September 11, 2023

**Re: H18-D070**  
**McDonald's 5900 Menaul Blvd. NE**  
**Langan Project No.: 520015201**

Thank you for taking the time to review the Traffic Circulation Layout for the McDonald's restaurant at 5900 Menaul Blvd. NE. We have addressed your comments as follows:

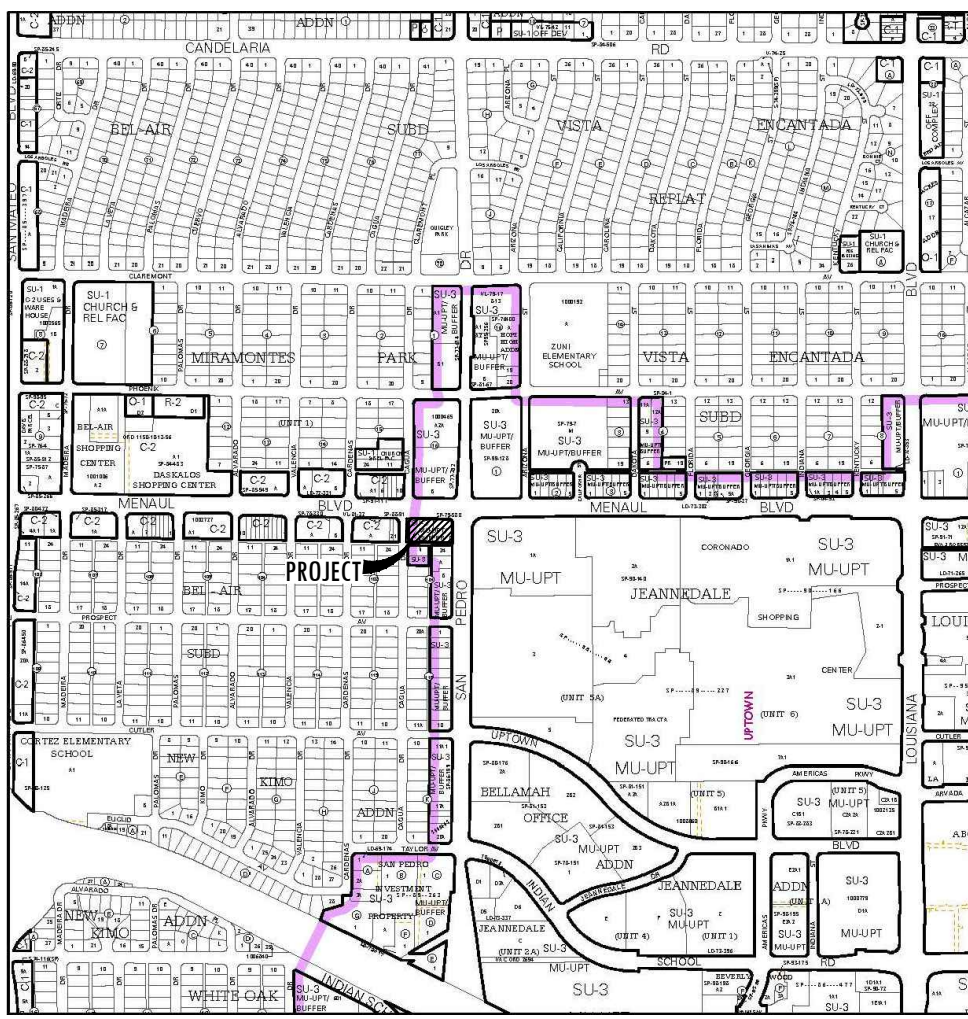
1. Please remove the Paving Specification Notes from the TCL sheet.
  - The Paving Specifications Notes have been removed from the TCL sheet.
2. Show the Bike Rack details either on sheet C10.1 or C10.4.
  - The Bike Rack details have been moved to Sheet C10.4.
3. Add a note stating "All broken or cracked sidewalk must be replaced with sidewalk and curb & gutter." A build note must be provided referring to the appropriate City Standard drawing.
  - The note has been added to the TCL, and refers to the appropriate City Standard Drawings.
4. Key note 32: Unused curb cuts must be replaced with sidewalk and curb & gutter. A build note must be provided referring to the appropriate City Standard drawing.
  - A note regarding the unused curb cuts has been added to the Notes. Keynote 36 has been added to the plan for the sidewalk referring to COA STD DWG 2430.
